Application for removal or variation of a condition following grant of
planning permission. Town and Country Planning Act 1990.
Planning (Listed Buildings and Conservation Areas) Act 1990

EXTENTIONS TO EXISTING WORKSHOPS/GARAGES

2016/0040

CONDITION 2

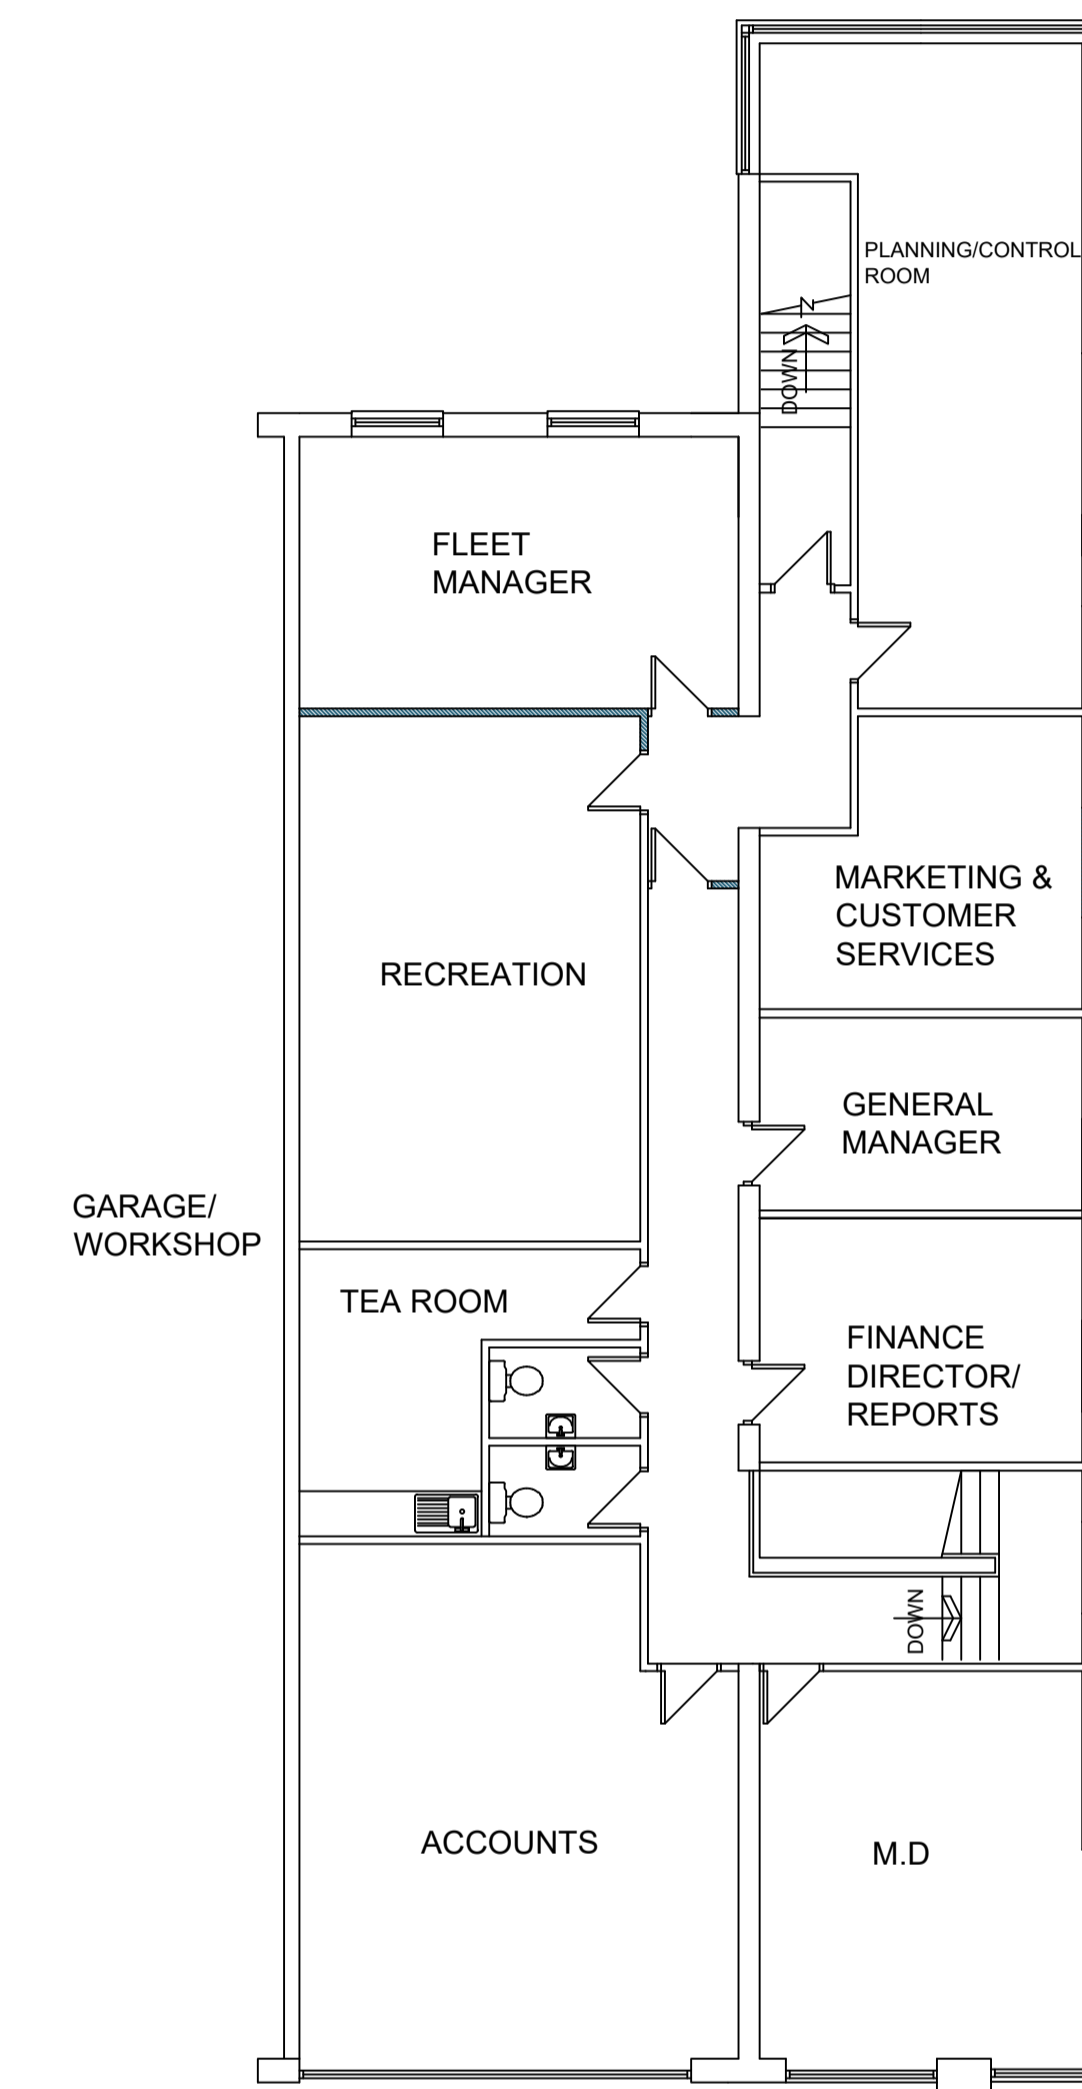
FOR OPERATIONAL REASONS AND TO ENSURE THAT THE NEW BUILDING PROVIDE THE BEST POSSIBLE, MODERN FACILITIES A MINIMUM 6M HEIGHT IS REQUIRED FOR THE ACCESS DOOR HEIGHT FOR VEHICLES. THIS WILL REQUIRE A COMPLETE NEW STEEL FRAME FOR THE EXISTING SECTION OF THE BUILDING. IN ADDITION, IT IS CONSIDERED APPROPRIATE TO DEMOLISH THE EXISTING SINGLE STOREY OFFICES & TO INCORPORATE NEW ONES WITHIN AN EXTENSION OF THE STEEL FRAME .

THE DRAWING REFERENCE IN CONDITION 2c) TO BE CHANGED TO 13-104-102
THE DRAWING REFERENCE IN CONDITION 2d) TO BE CHANGED TO 13-104-103
